Office of
Environment
& Heritage

DOC16/250373
SSD 7228

Response to Submissions – Sydney Zoo, Bungarribee Park (SSD 7228)

ATTACHMENT 1: Office of Environment and Heritage (OEH) comments on the Response to Submissions for Sydney Zoo (SSD 7228)

EXISTING CUMBERLAND PLAIN VEGETATION TO BE REMOVED **2367M2 (0.24hA)**

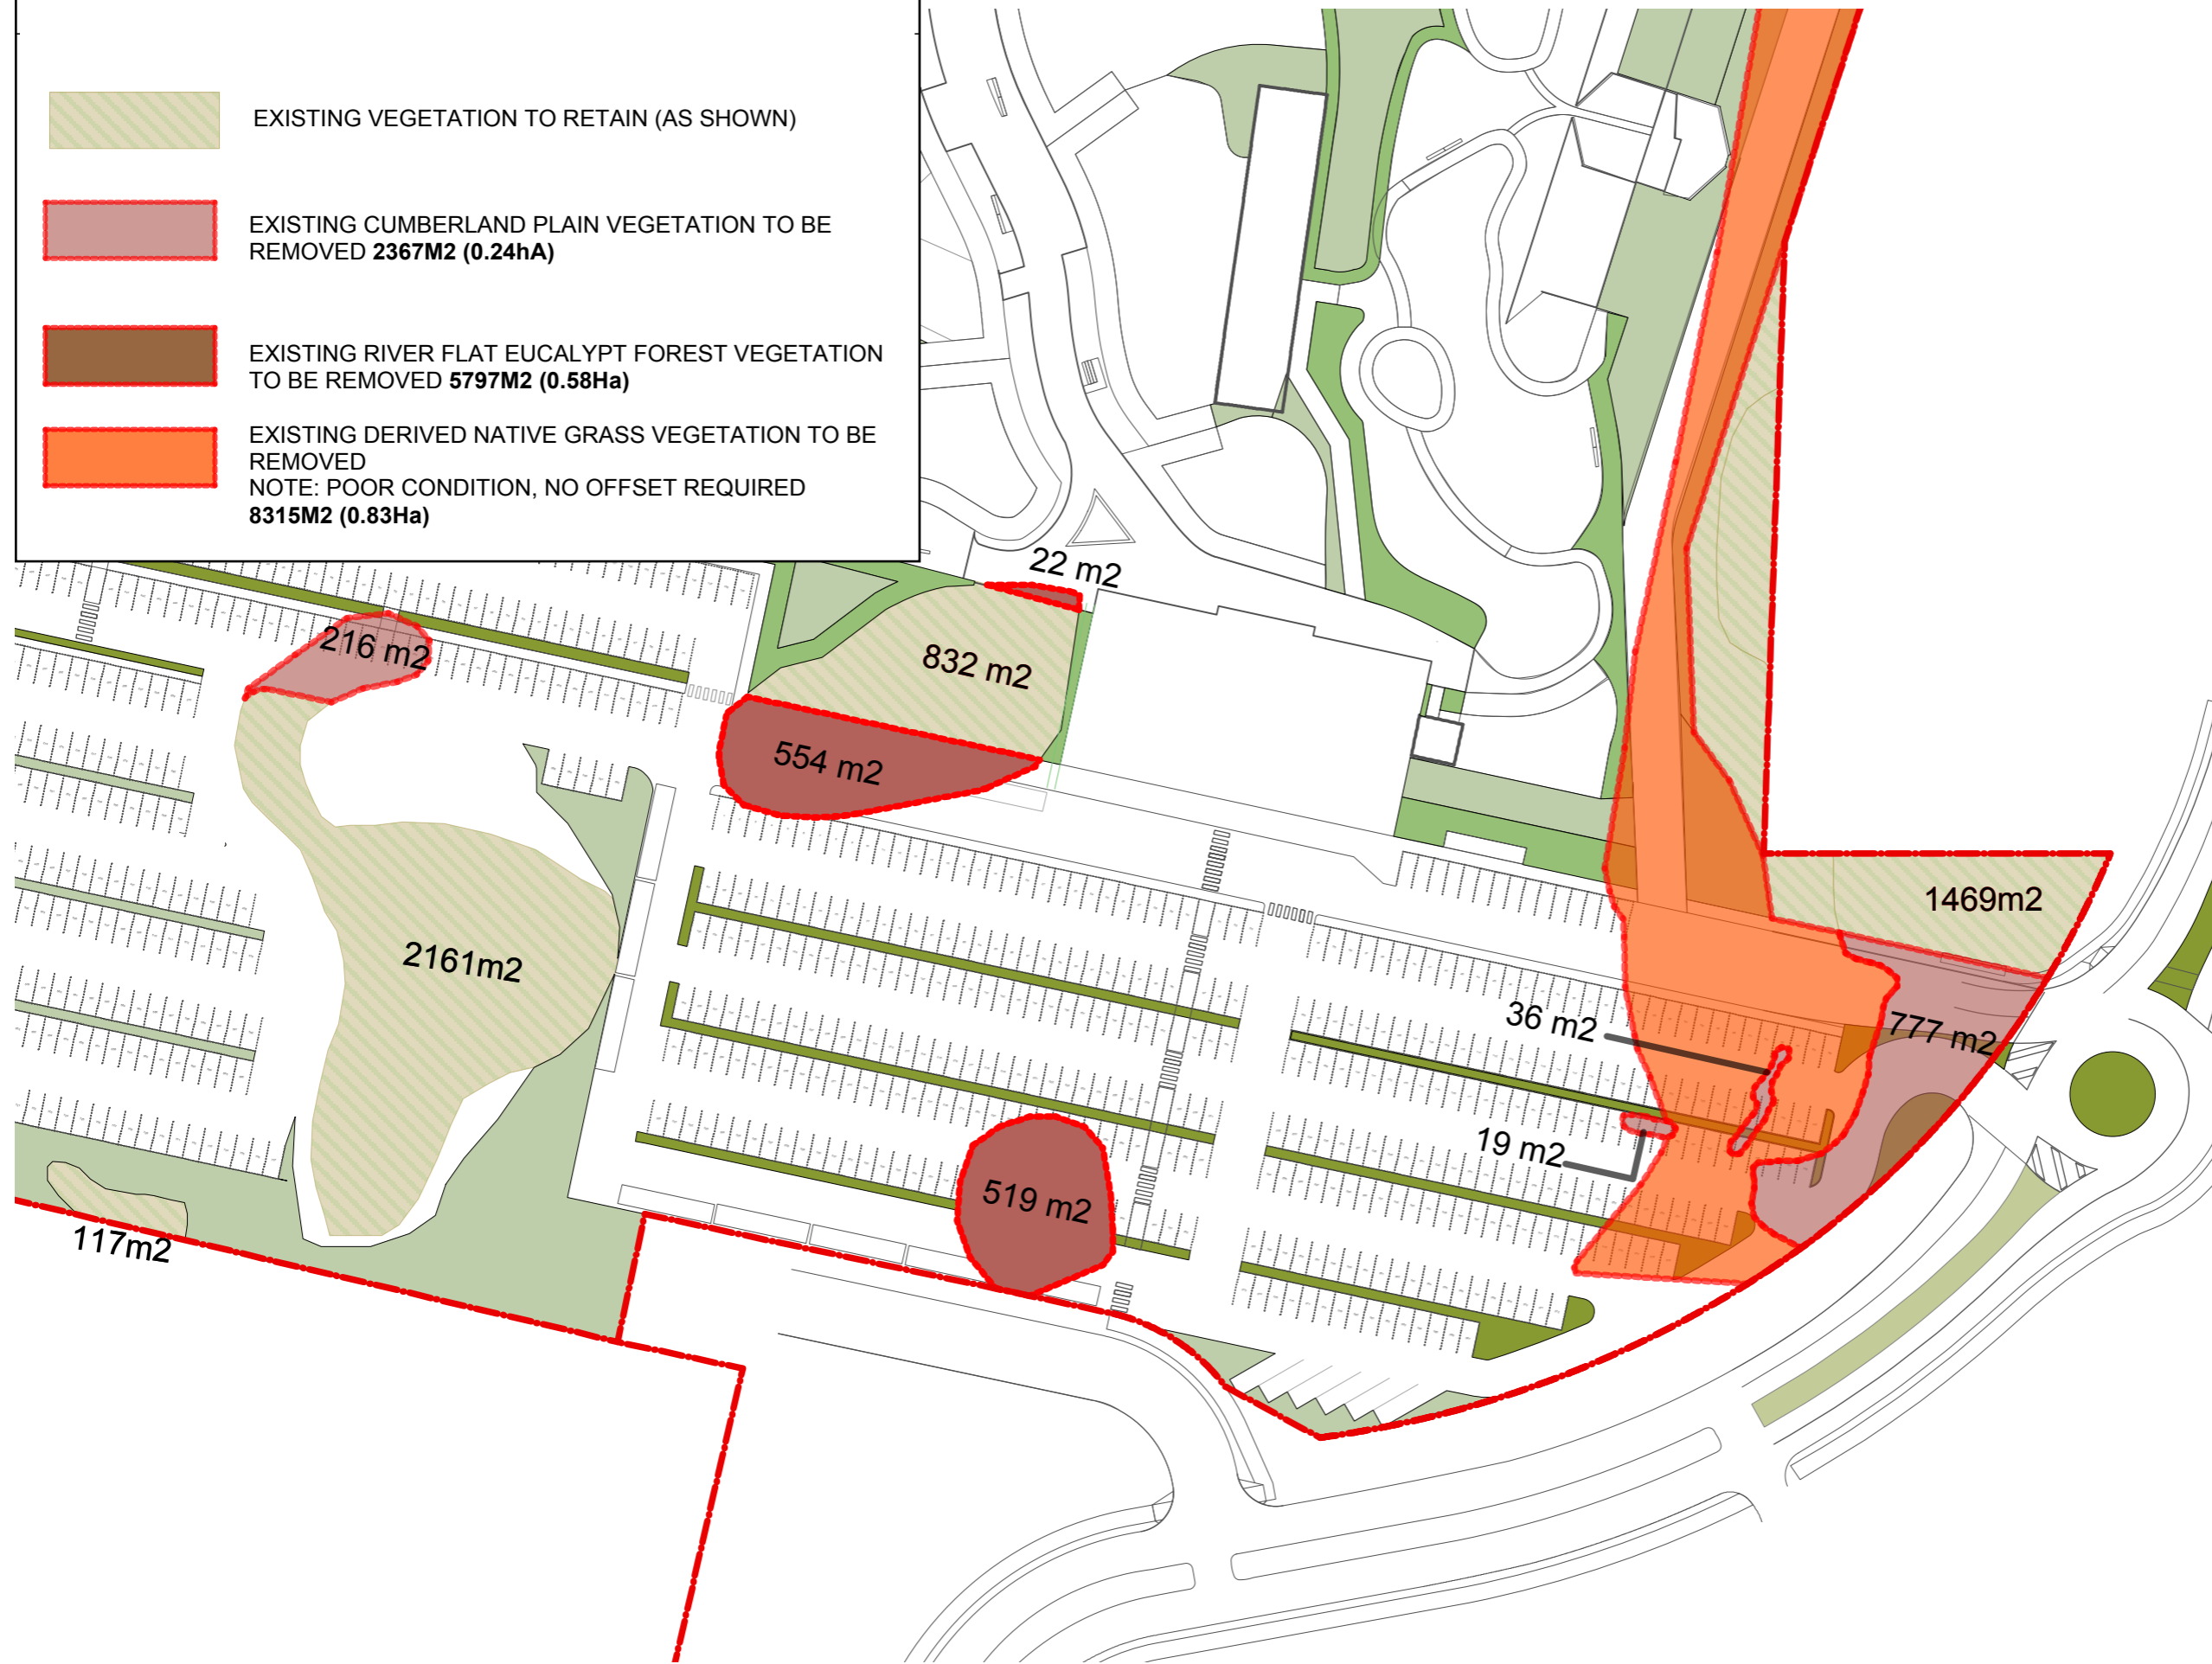
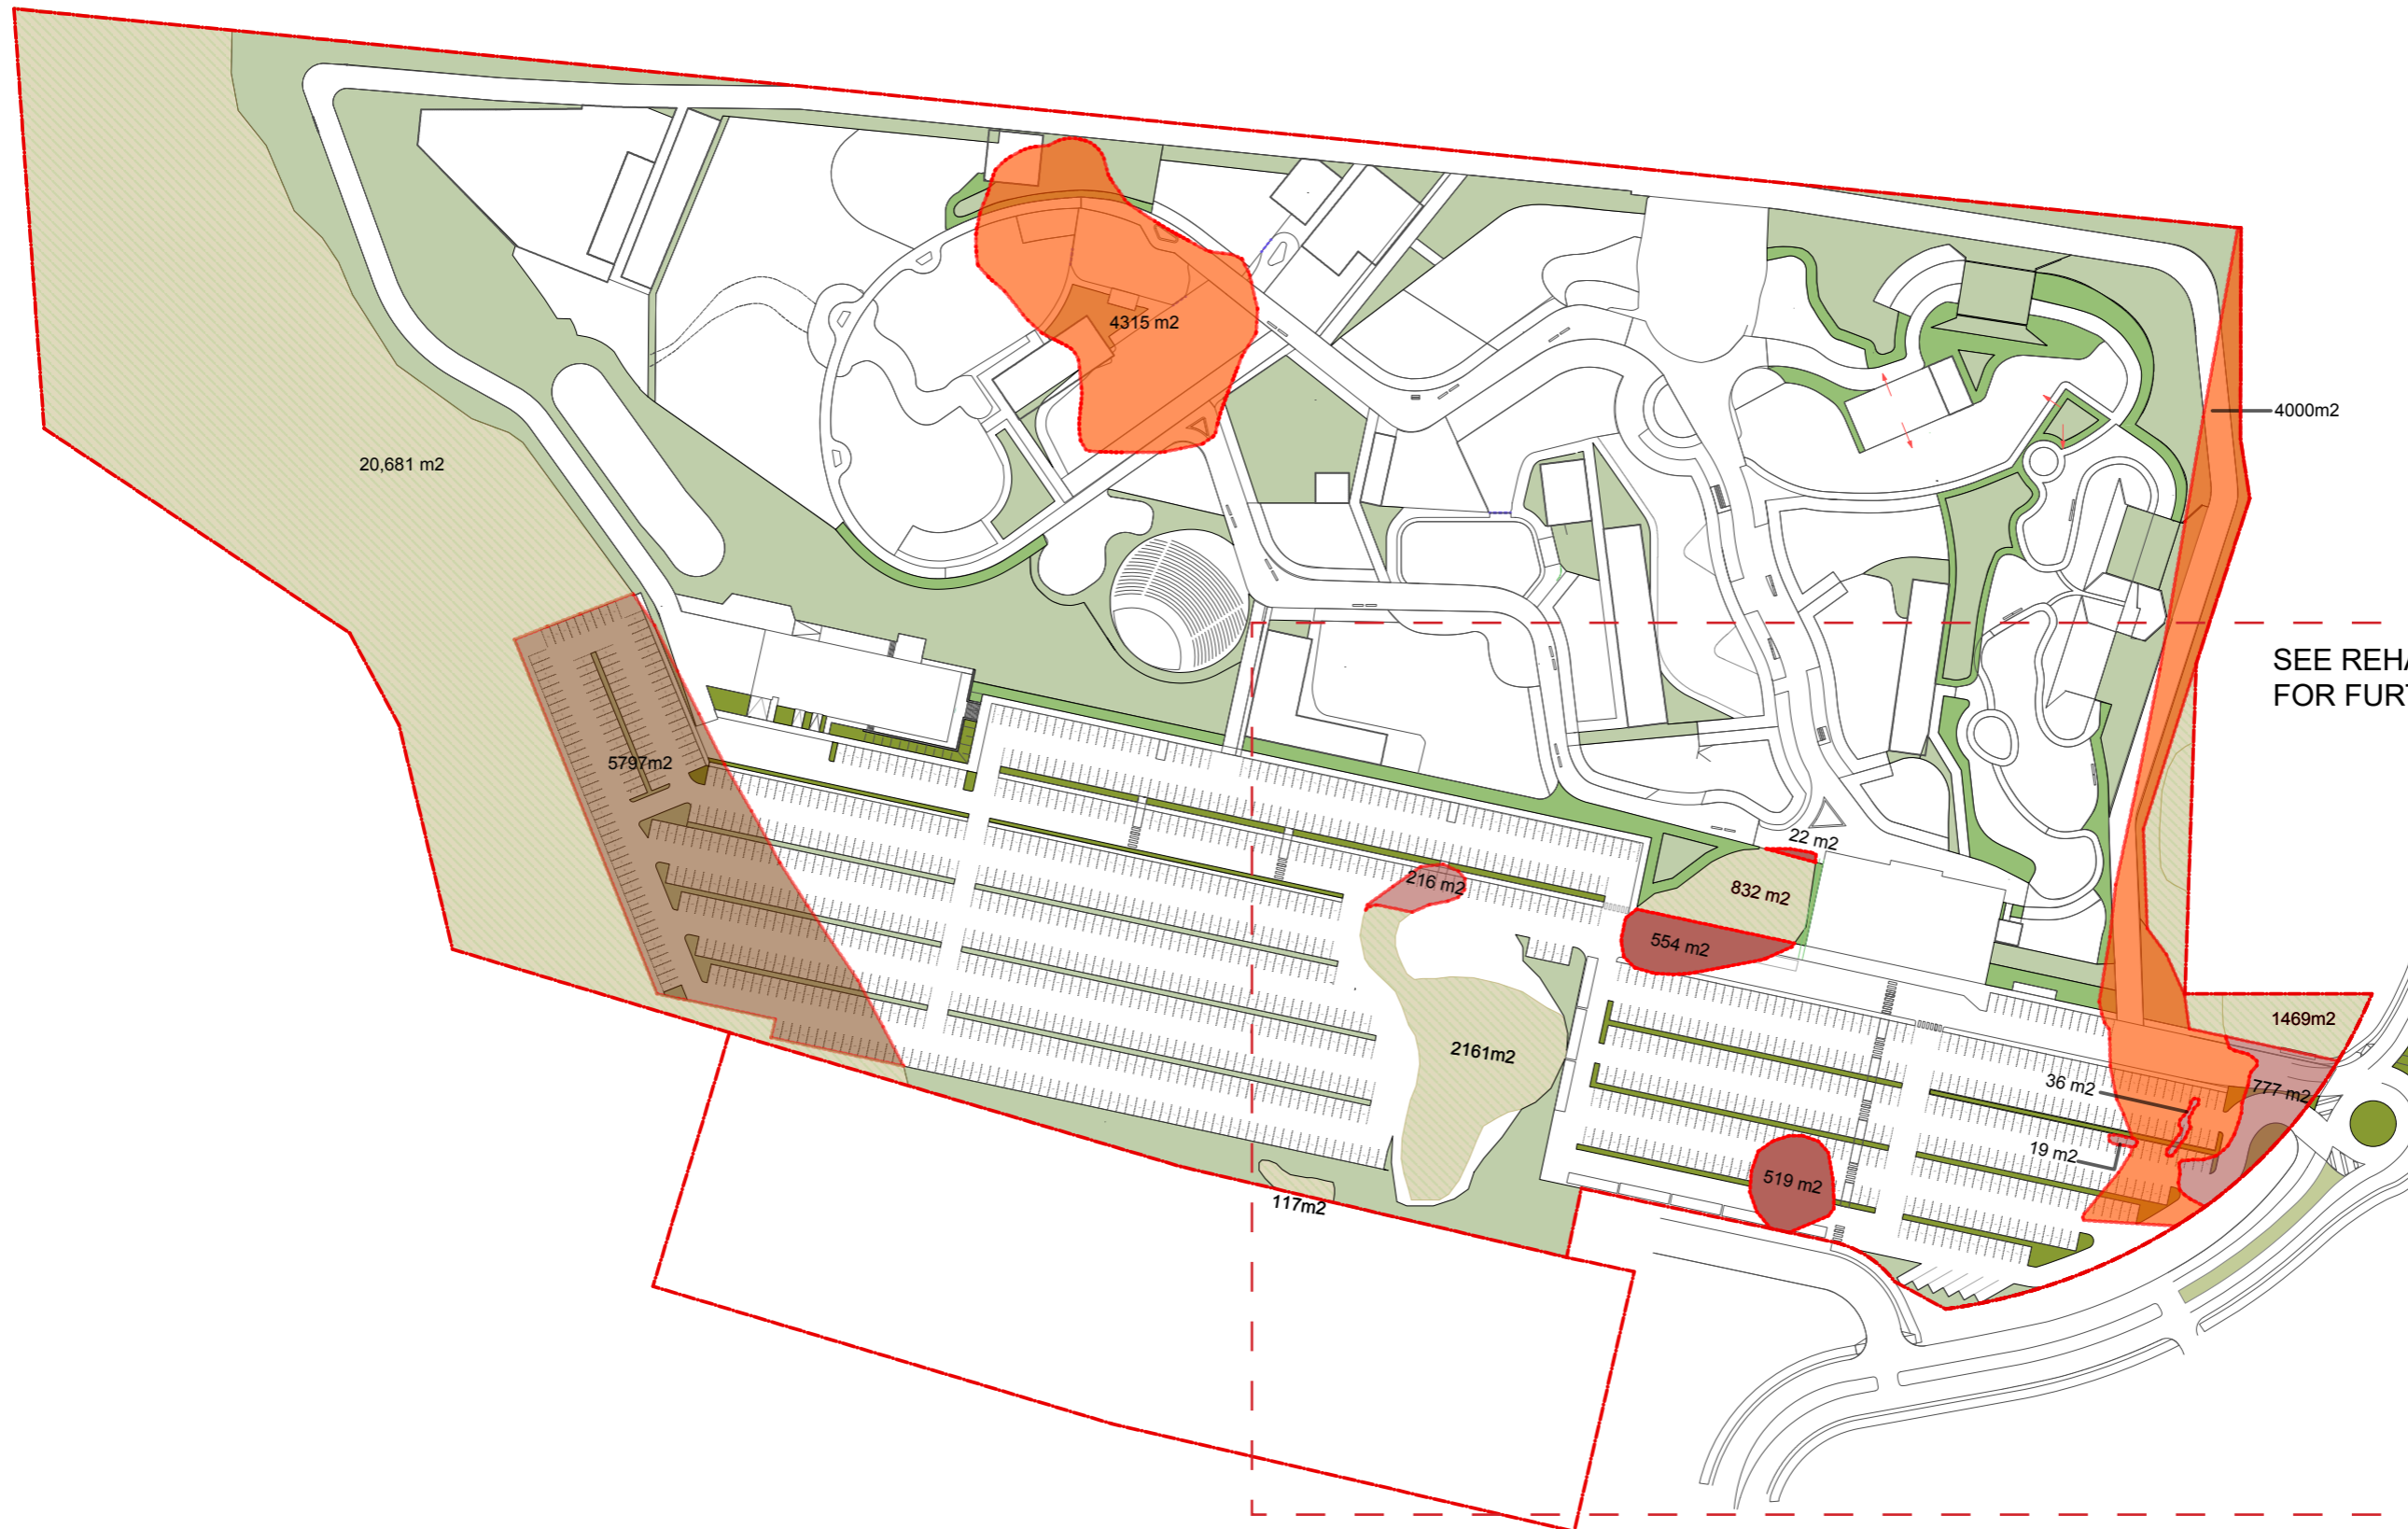
Therefore, there is no 0.25ha threshold under the Offsets Policy and FBA and subsequently offsets will be required for the loss of 0.24ha of CPW as a result of this proposal.

Landscape Masterplan Part 15 (DWG L22 Rev A) is not consistent with the GIS shapefile for 'retained' land: the plan shows 'asphalt car park' over the northern part of the largest 'retained' patch of CPW. However, part of this area is also mapped as 'exotic'; see above. Please clarify the extent of land to be 'retained'.	Drawing L22 was illustrative as a demonstration of car park zones, it inaccurately shows impact on the patch referenced that is different from the actual plans. This has been amended. The area contains both exotic and CW species as there is a construction buffer established around the CPW to assist in its preservation.	Noted.
OEH notes that surveys were undertaken at a suitable time of year for all the flora species except potentially <i>Pimelea spicata</i>. <i>Pspicata</i> can appear any time of year but mostly in summer, and can be difficult to detect when not in flower. As no surveys	According to the 'Survey time matrix' from the assessment tool and Threatened Species Profile Database, <i>Pimelea spicata</i> can be surveyed for at any time of year (Jan - Dec). Survey did not detect this species, and the habitat was disturbed with little understorey,	Noted.
